# Householder Proforma

**Application Ref:** 2023/0314

**Address:** The Dairy, Cockle Edge, Huddersfield Road, Ingbirchworth, S36 7GF

**Proposed:** The proposal is for the erection of a single storey rear extension to the dwelling forming a boot room and sitting room. The boot room will project 4.35m and measure 1.88m in width, 2.65m to the eaves, 2.75m total height and the attached sitting room will project 3.05m, measure 5.90m in width, 2.58m to the eaves and 2.73m total height. The boot room will be built in matching stone and the sitting room will have a fully glazed elevation of sliding doors. The entire extension will have a flat roof and the boot room will have a side facing high level window.

PROPOSED ELEVATIONS

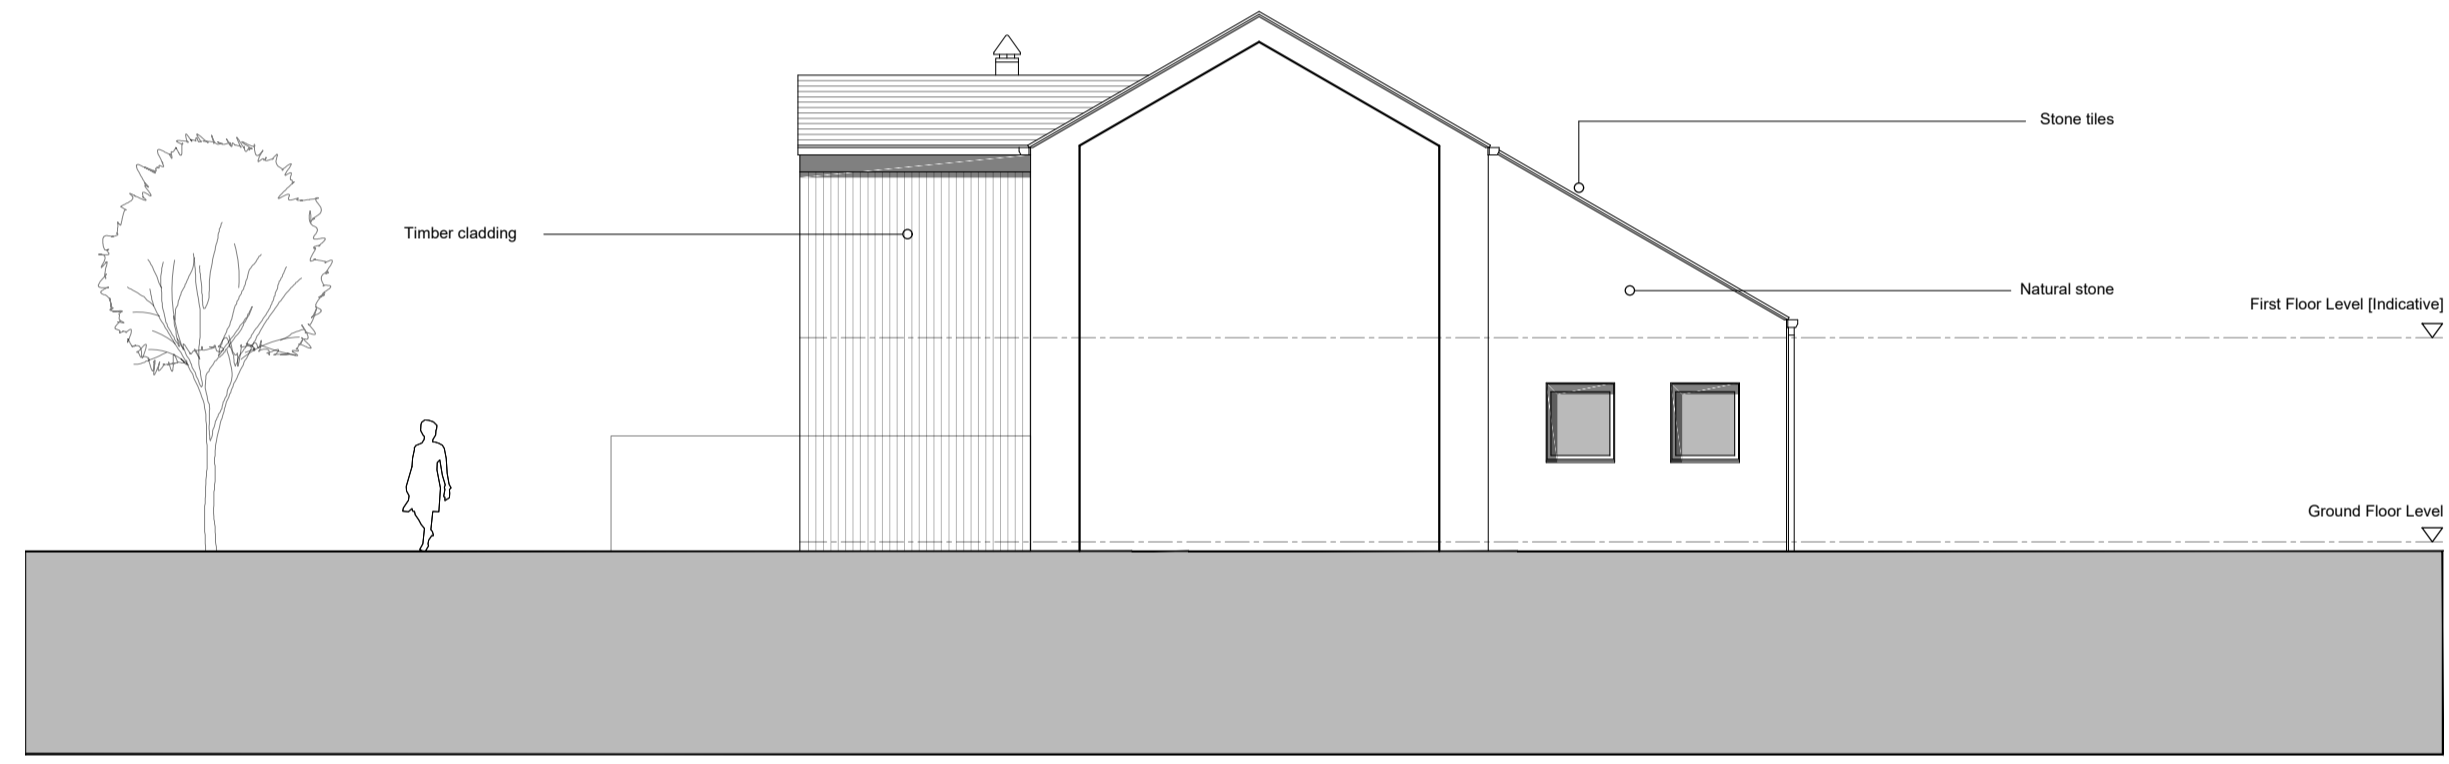
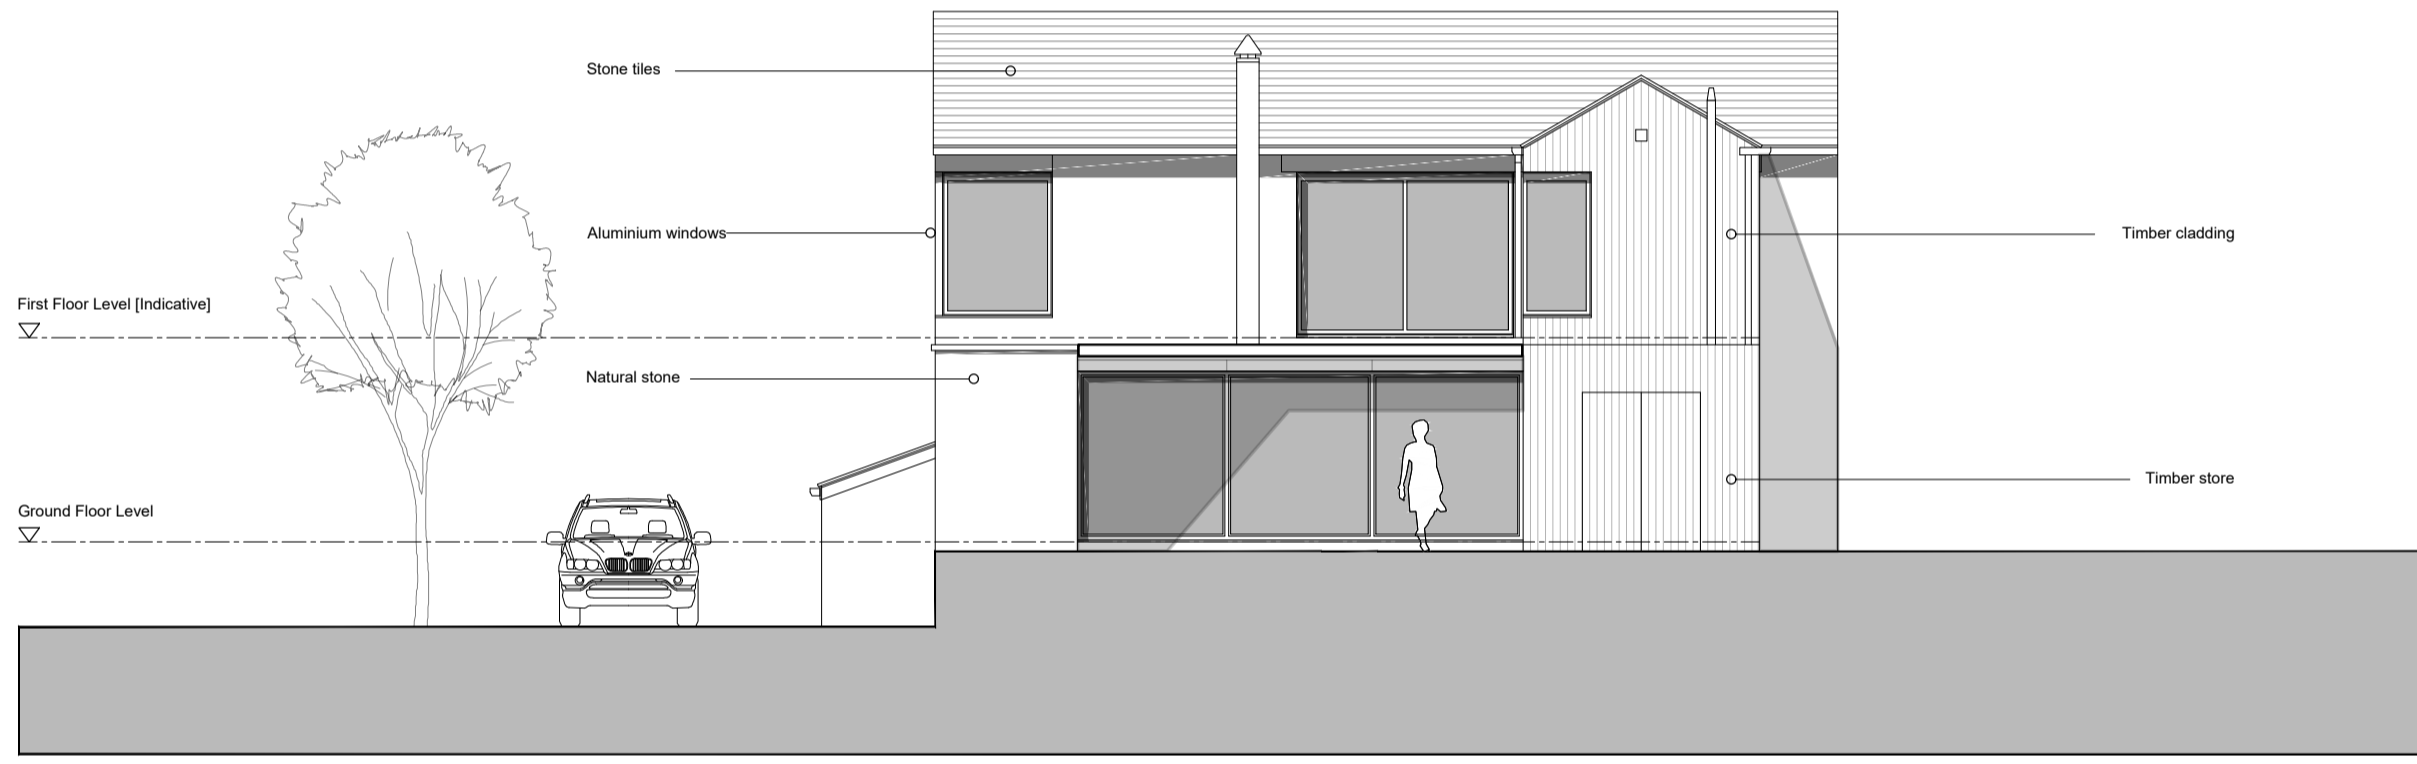
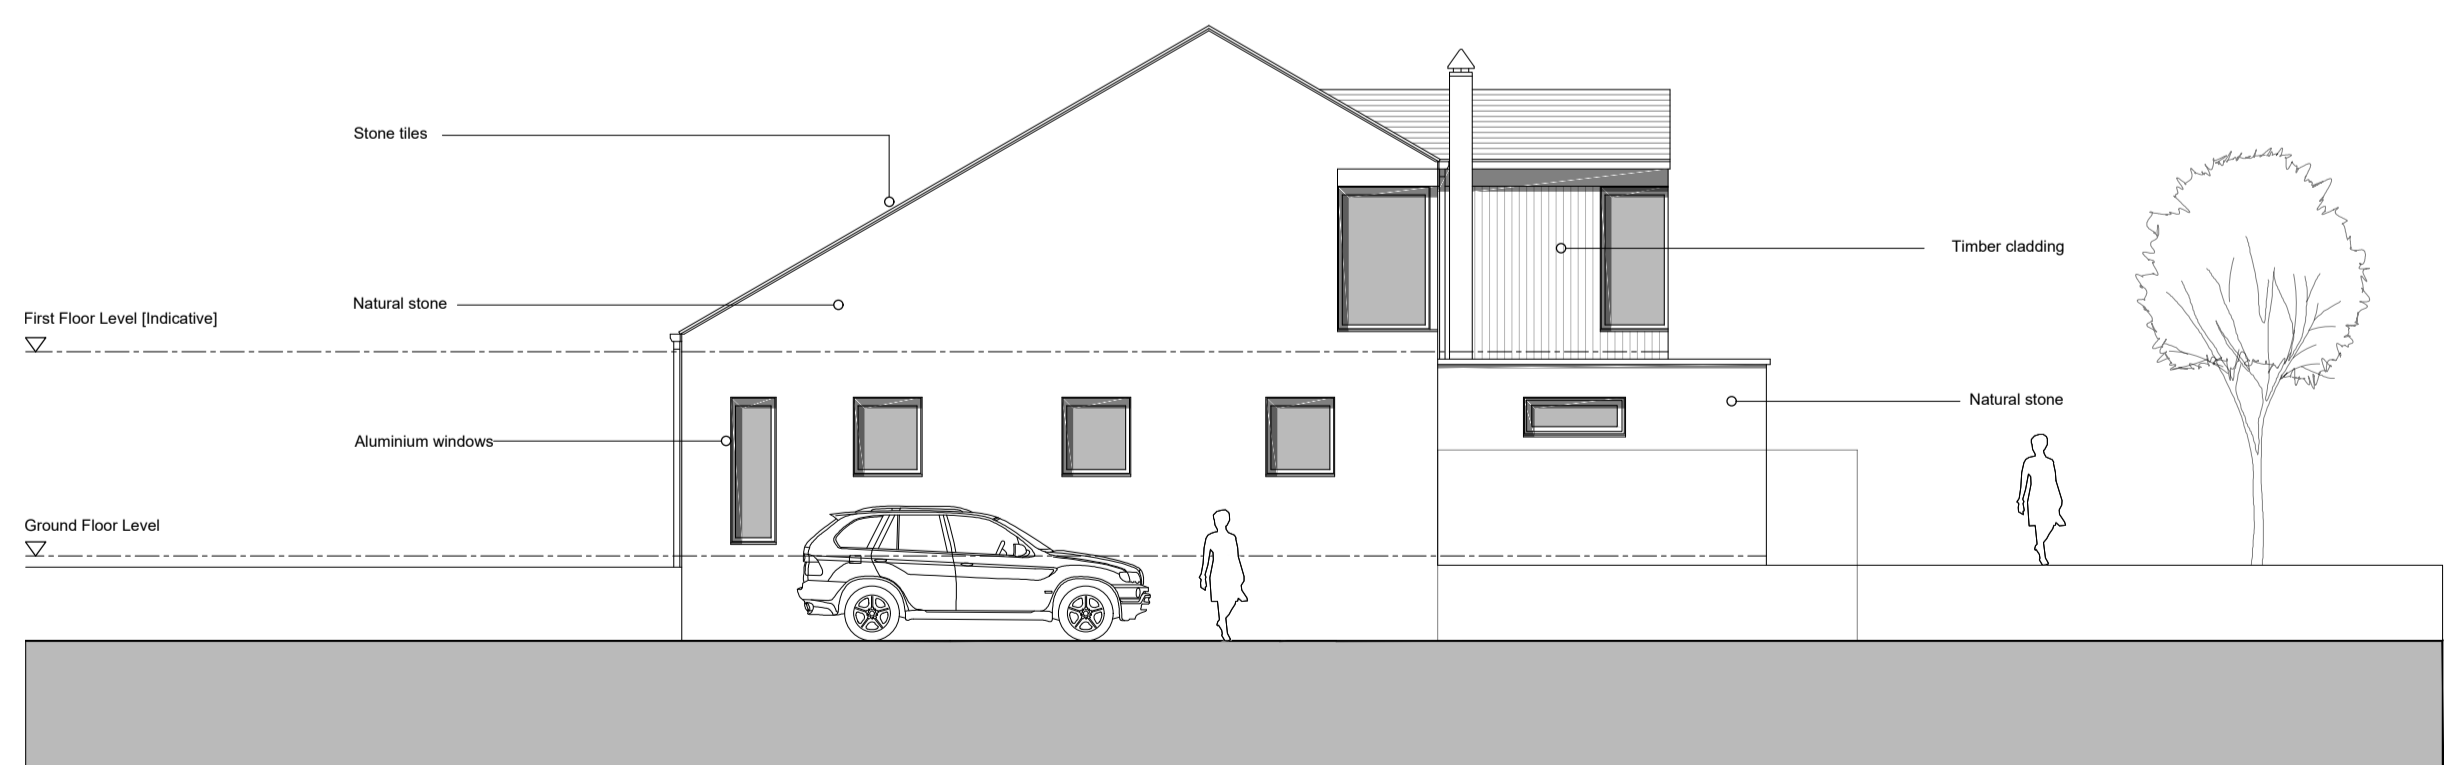
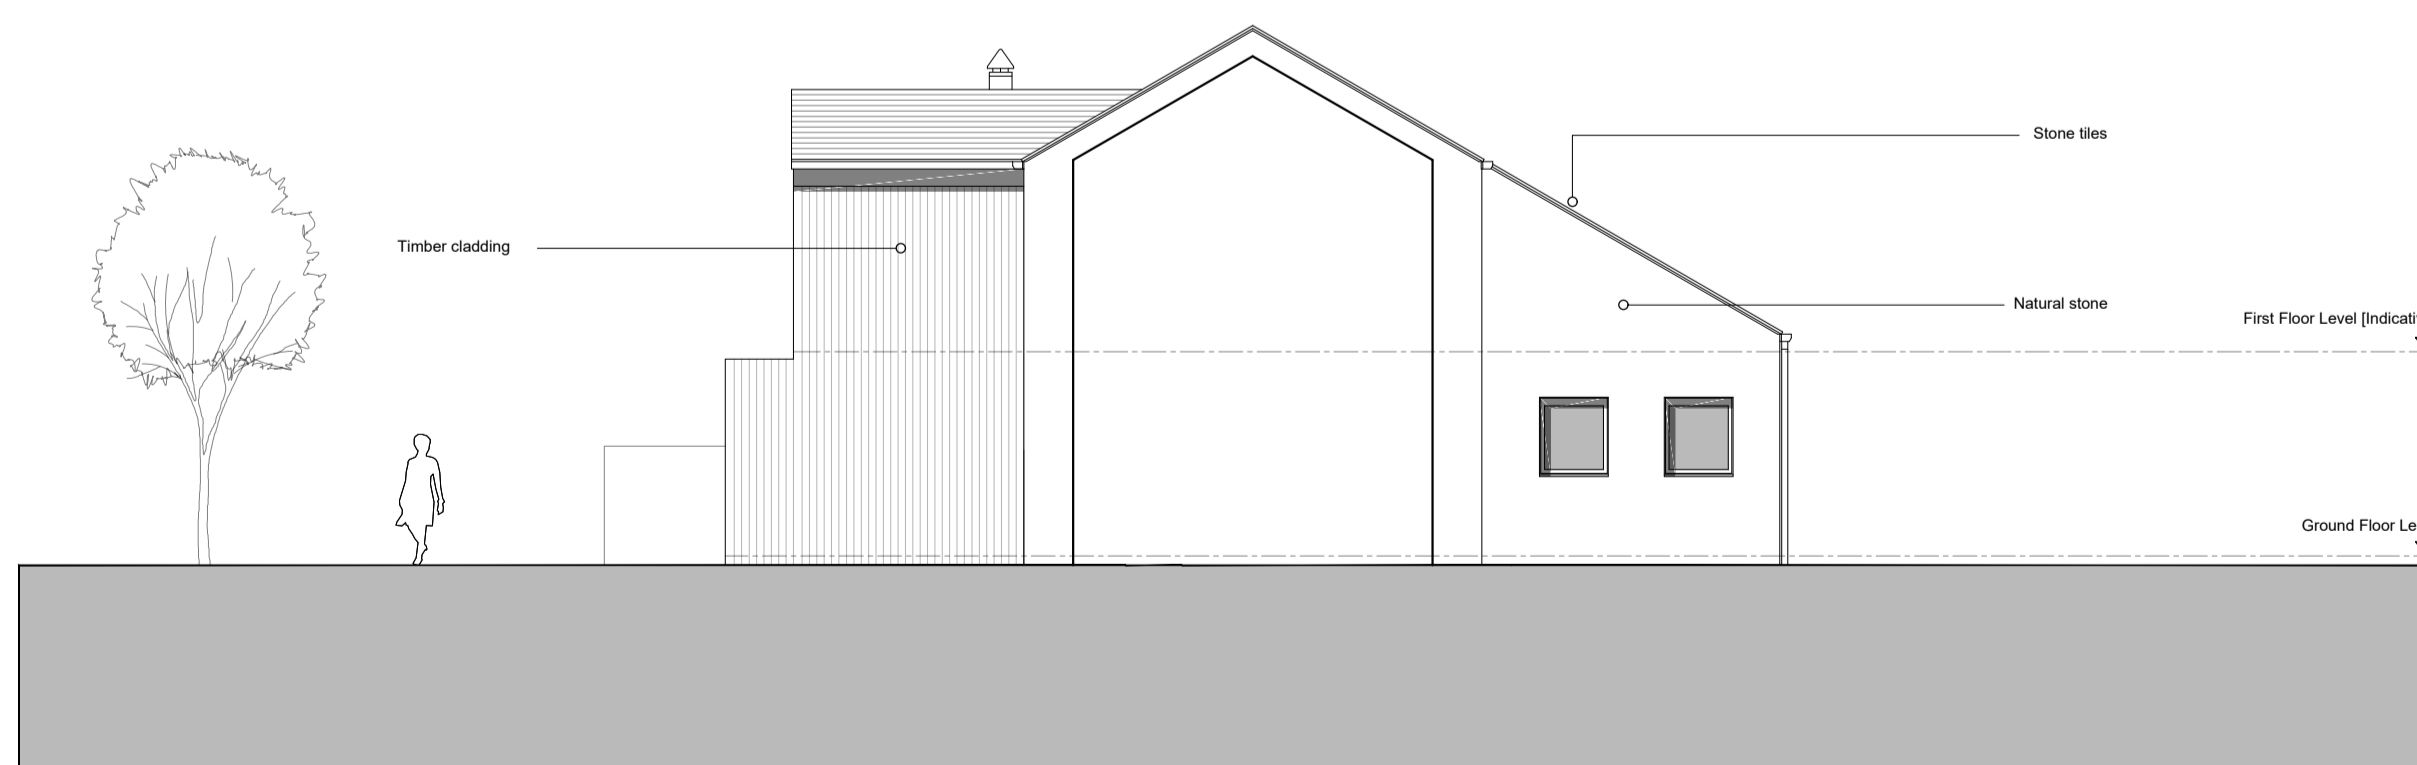
Yes
Single Storey	
1. terraced property and less than 3.5m (projection to rear)?	
2. semi-detached and less than 4m?	<p>The boot room will project 4.35m and the sitting room 3.05m. This will not impact on the adjoining neighbour due to the position away from the shared boundary.</p> <p>The timber clad storeroom will project a further 1.35m from the existing rear projection which will result in a rear projection of 4.3m in total. This is located on the adjoining boundary therefore will have the potential to impact the adjoining neighbour. The adjoining neighbour has a large two storey projection on the rear elevation which is already overshadowing a window at the rear. The enlargement of the existing timer projection will cause some impact to the neighbour's window however, the rear elevation is south facing, the proposal will have a flat roof and only project a further 1.35m, 0.3m over policy requirements. The previous application allowed a smaller projection of 0.95m. Furthermore, there is an existing boundary fence along the shared boundary, therefore, taking that into account, when assessed along with the sun path and existing projections the increase of 0.3m is not expected to be significant.</p>

3. if more than 3m are the eaves more than 2.5m in height?	<p>The eaves are 2.58m and 2.65m for the boot room and sitting room which is just over the recommended 2.5m, and with a total height of 2.73m. The storeroom has a total height of 2.73m. The boot room and sitting room will not impact the adjoining neighbour as there is a 2-storey extension located on the adjoining boundary.</p> <p>The enlargement of the existing timer projection will cause some impact to the neighbour's window however, the rear elevation is south facing, the proposal will have a flat roof and only project a further 1.35m, 0.3m over policy requirements. The previous application allowed a smaller</p>

projection of 0.95m. The neighbour has an existing two storey rear extension which already has some impact on their own rear window. Furthermore, there is an existing boundary fence along the shared boundary, therefore, taking that into account, when assessed along with the sun path and existing projections, the flat roof will help to reduce the potential impact and is therefore acceptable within this setting.
Two Storey

7. roof design compliments / ties in well	The proposed roof type is flat, and although will not match the existing property, due to the tall windows on the first floor, a flat roof design is the only suitable roof type within this location. Furthermore, it should be noted that the barn conversion has a contemporary ambiance to the rear of the property, therefore when viewed alongside the modern additions is not expected to appear at odds within this setting.

8. habitable room windows on the side elevation?	No, a high-level window serving the boot room is proposed which is not expected to cause any overlooking in compliance with Local Plan Policy.
